Feasibility Report

**Conversion of Grade II Listed Office Building back to
a Dwelling**

December 2020

Headmasters Hall,

Project: Headmasters Hall, Wainsford Road  
Drawing: Proposed Ground and First Floor Plans  
Drawing No: 2020\_PP-011  
Scale: 1:100 @A3  
Date: October 2020

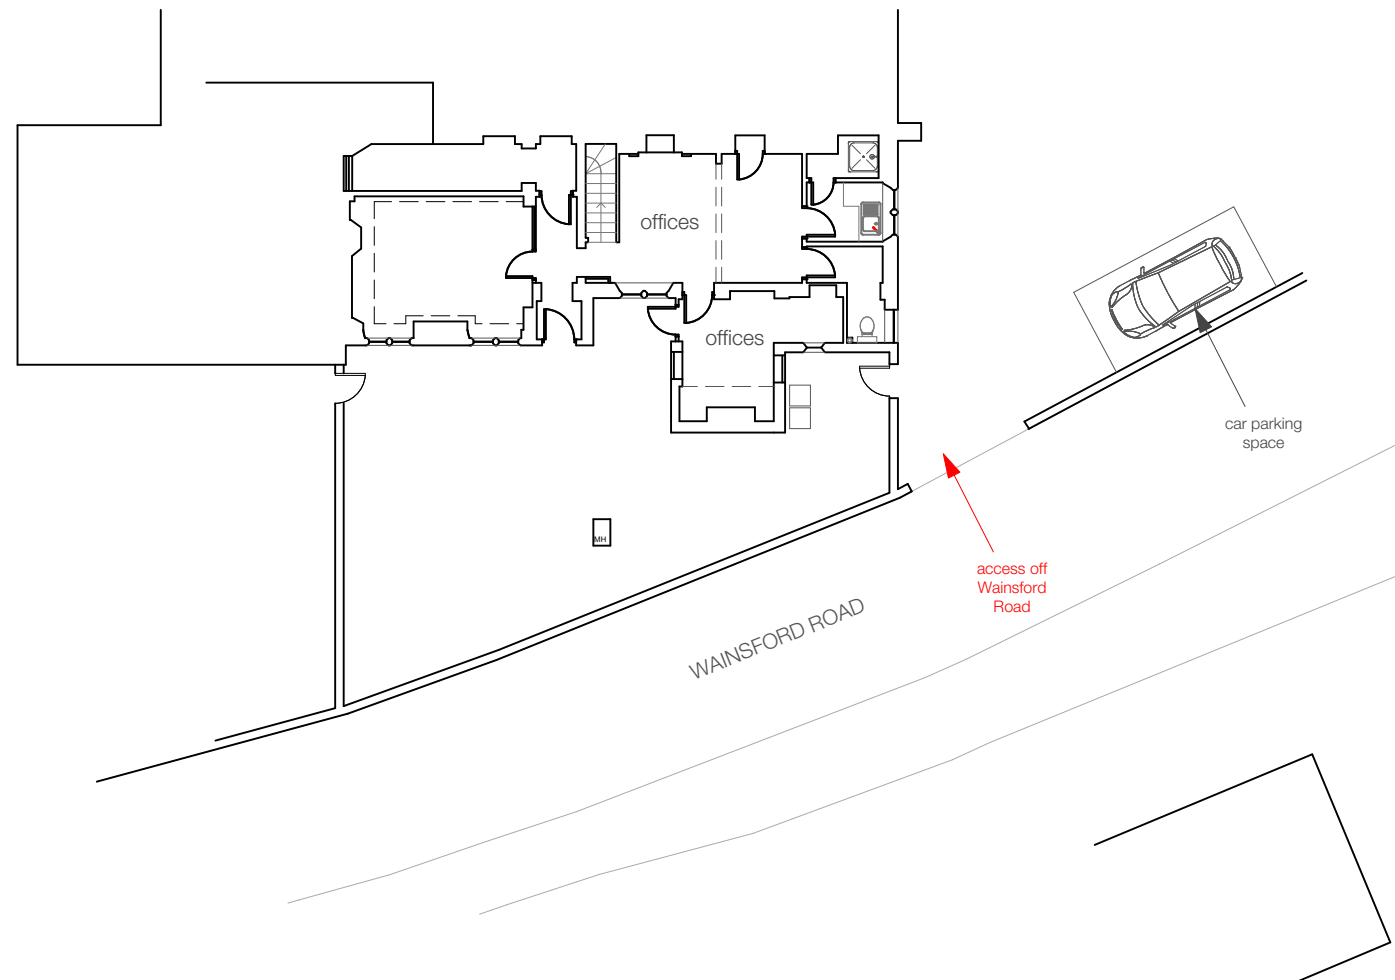
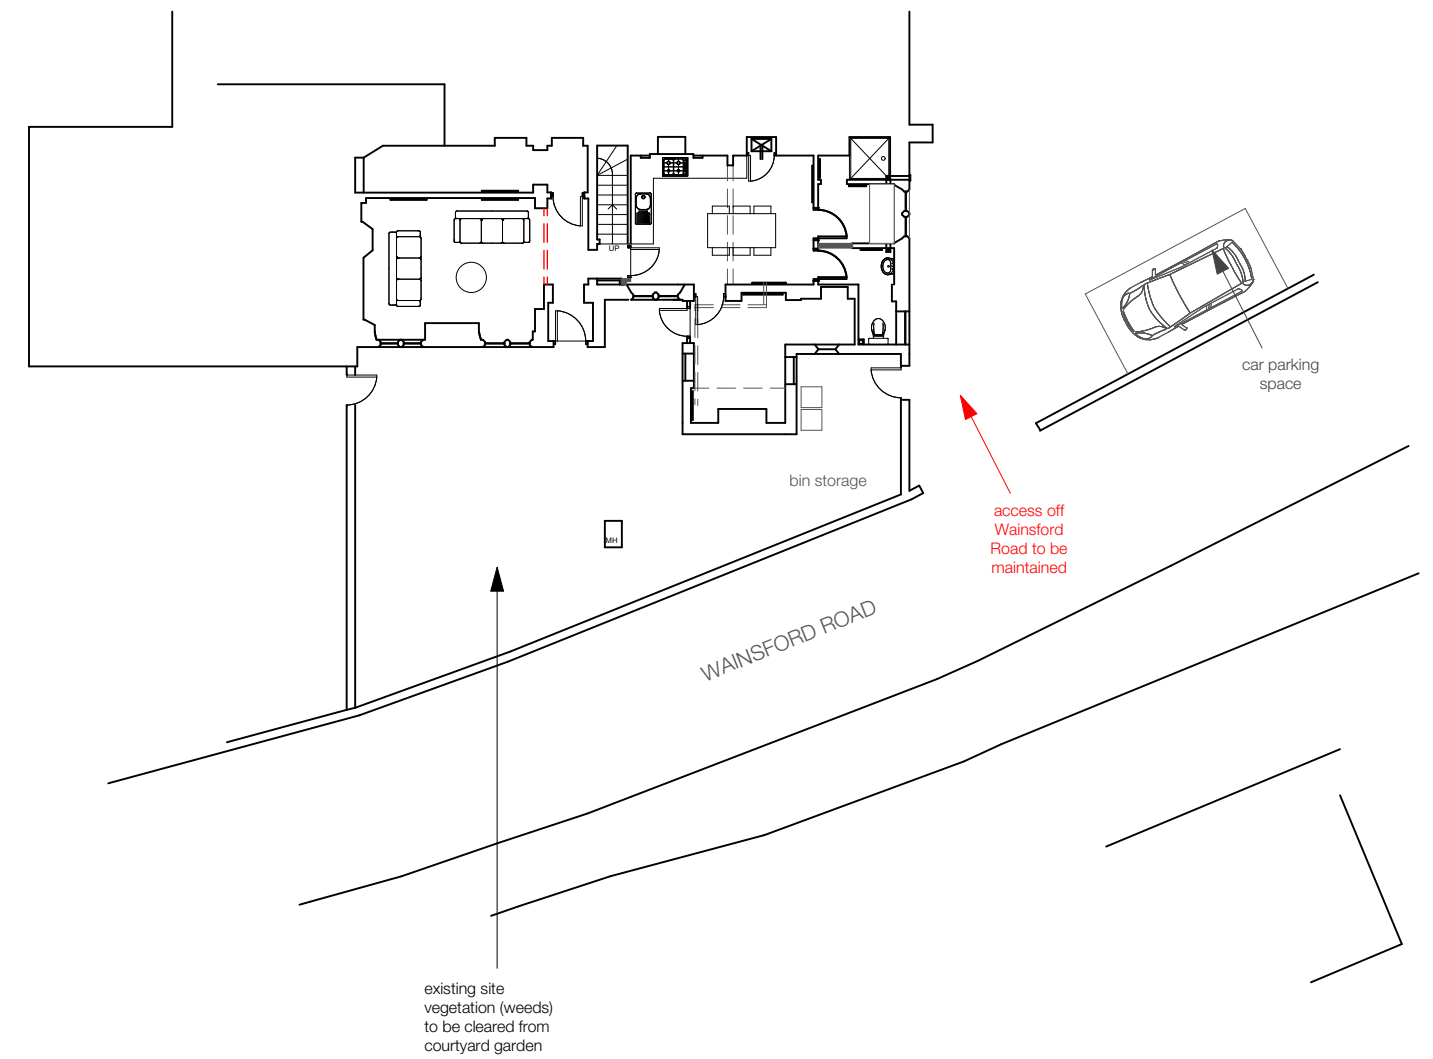
Internally some alterations are proposed to remove some of the existing walls. One wall has been classified as modern on the proposed plans, but what of the other walls proposed to be removed within the proposed living room and kitchen? Are the existing doors modern or historic and what is the proposal for them? Is there an opening to be blocked within the bedroom on the first floor?

We are not proposing to remove any of the original walls/partitions. We are proposing to remove a glazed partition that was introduced to the building in more recent years, which can be

seen on page 17 but this can also be appreciated if the Conservation Officer visits the building. Other areas we propose to alter are one existing doorway, which we are looking to block up and new internal stud work partitions, on the upper floor, which are designed to achieve a 30min fire rating (in order for a fire lobby to be created around the existing stairwell area).

Project: Headmasters Hall, Wainsford Road
Drawing: Proposed First Floor Plan
Drawing No: 2020_PP-014
Scale: 1:50 @A3
Date: March 2021

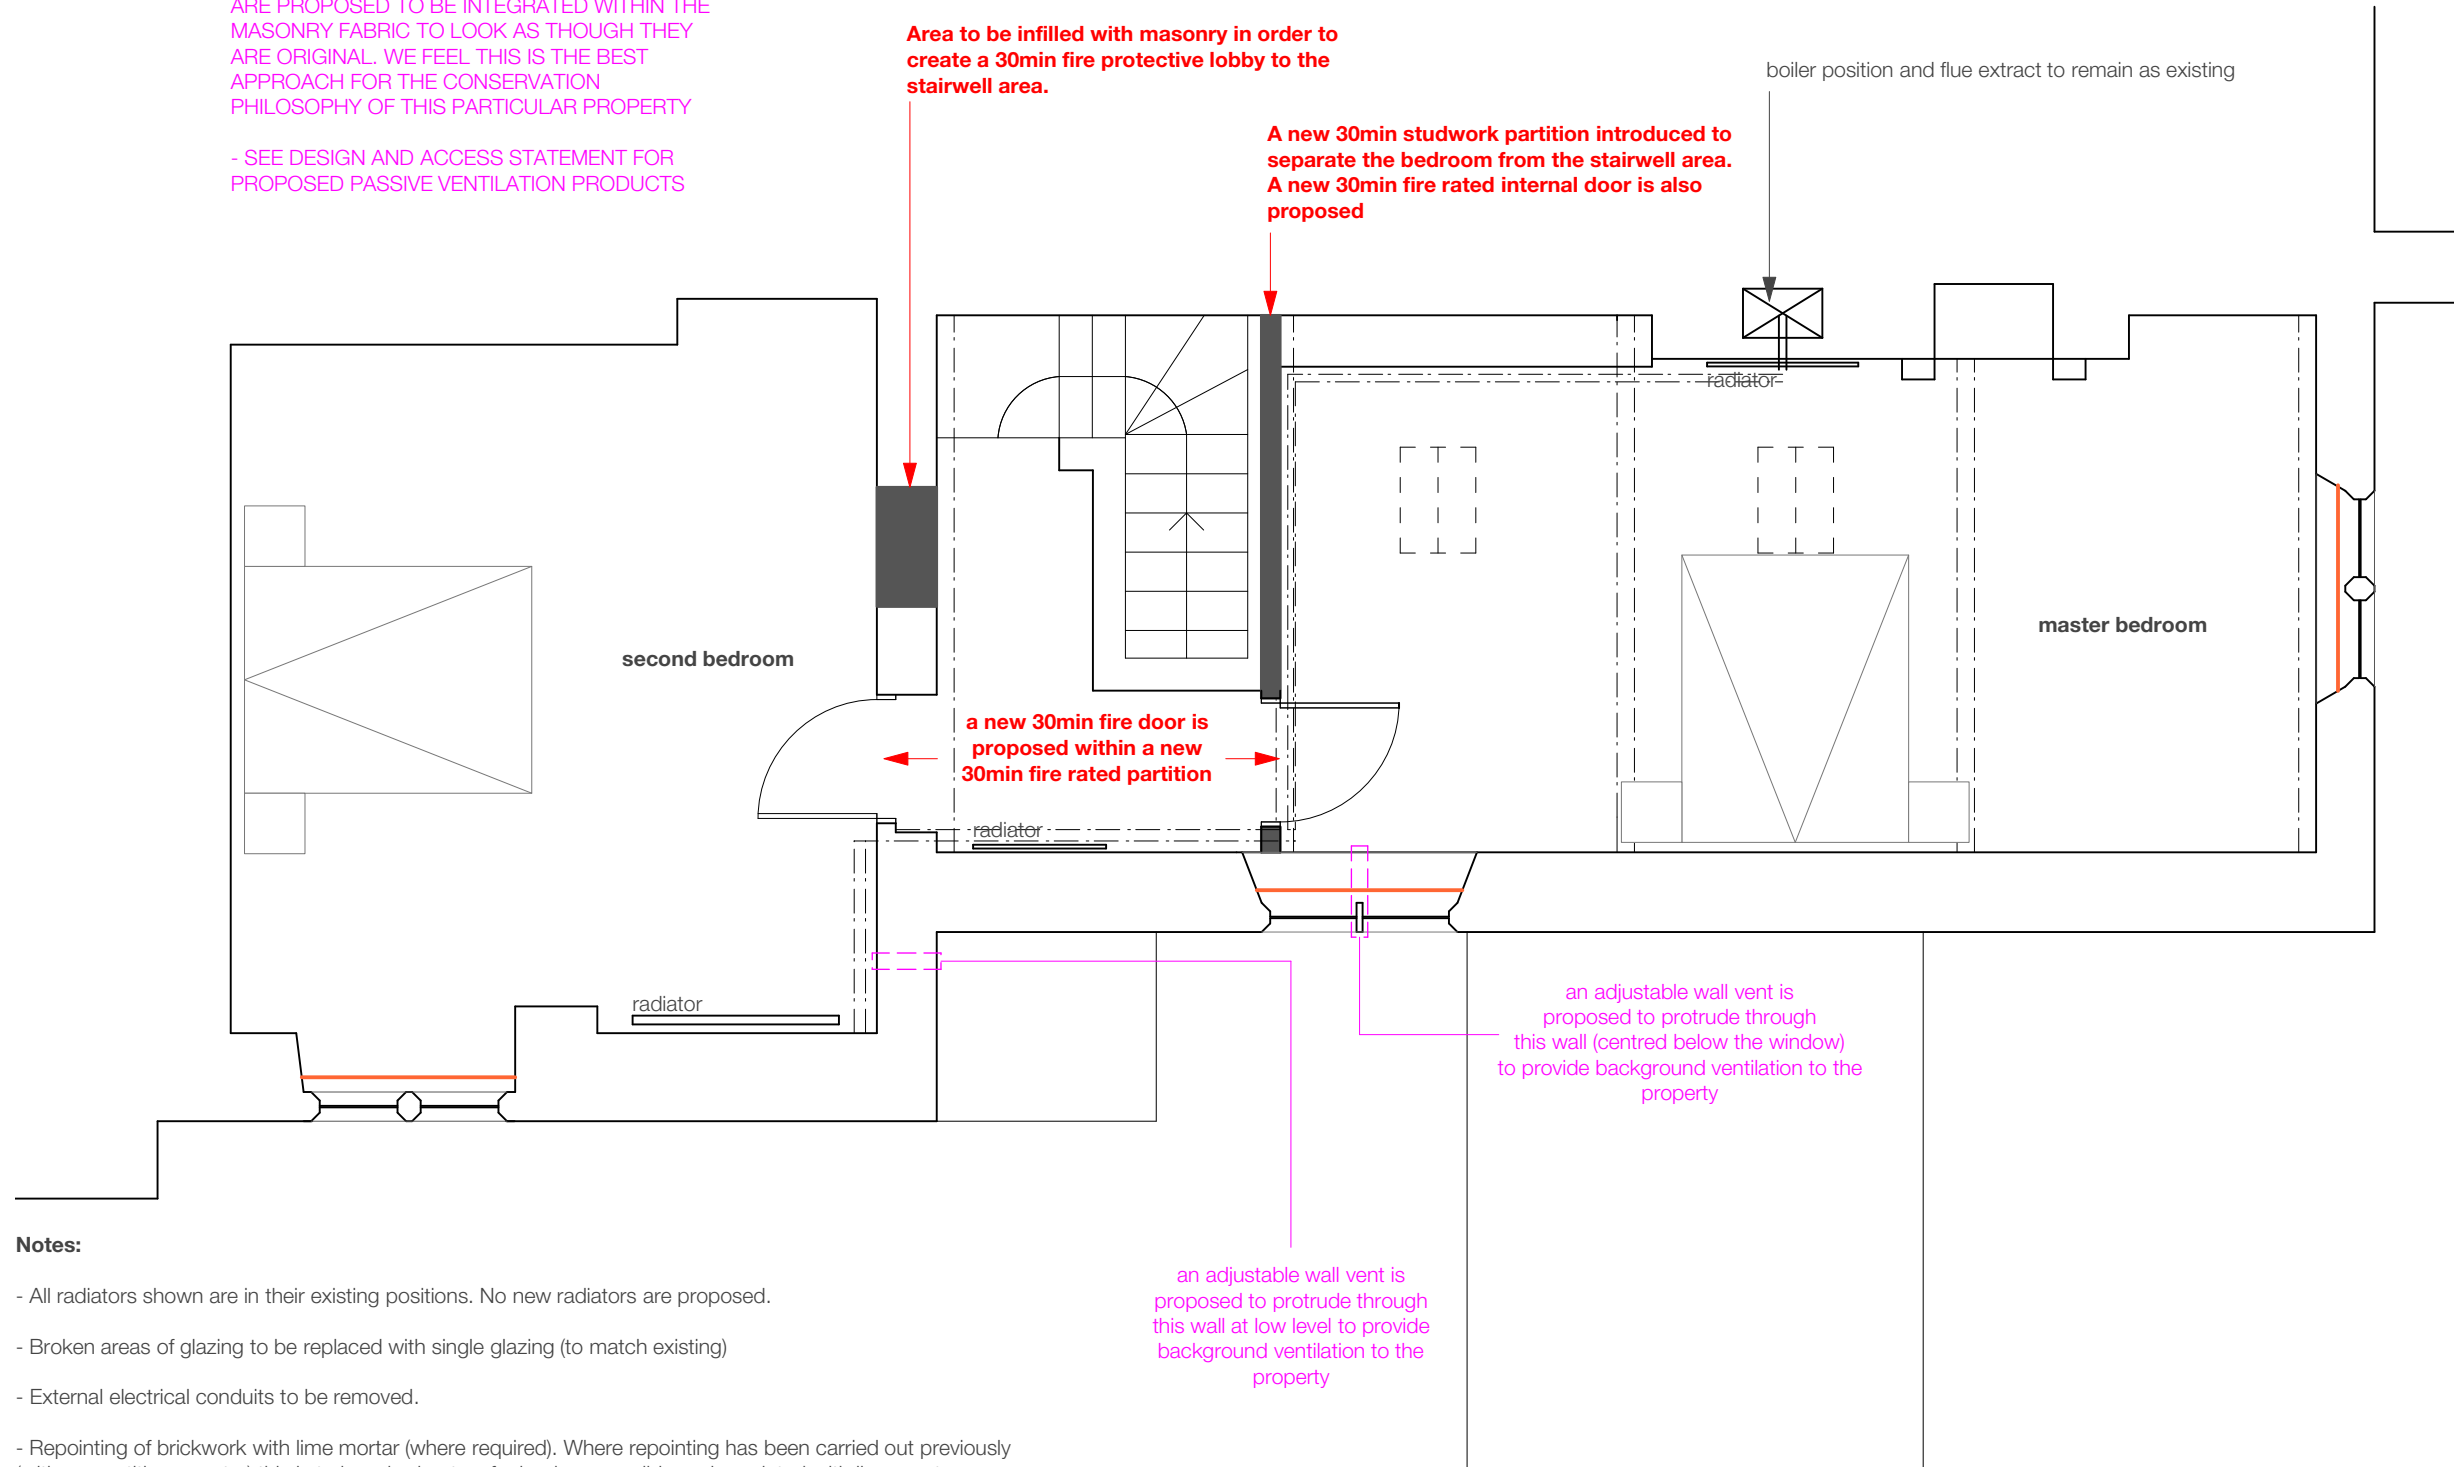
Is there any sound insulation proposed? Fire prevention measures or alarm systems proposed? How would the flue from the new boiler exit the building and what would it look like? Is any insulation proposed between the ceiling rafters/floor joists, and if so, what type of insulation?

- No intruder alarm system is proposed and the building (which has been used for commercial purposes in recent years) already has a fire alarm system installed. Further mains wired detectors may be required on the upper floor in particular where bedrooms are to be reinstated.
- The existing boiler is in good condition so we therefore do not propose to replace this or the flue that is connected to it.
- The building has adequate thermal and acoustic insulation to meet Building Regulation requirements. The ceiling is vaulted and thermal insulation has been installed above this already.
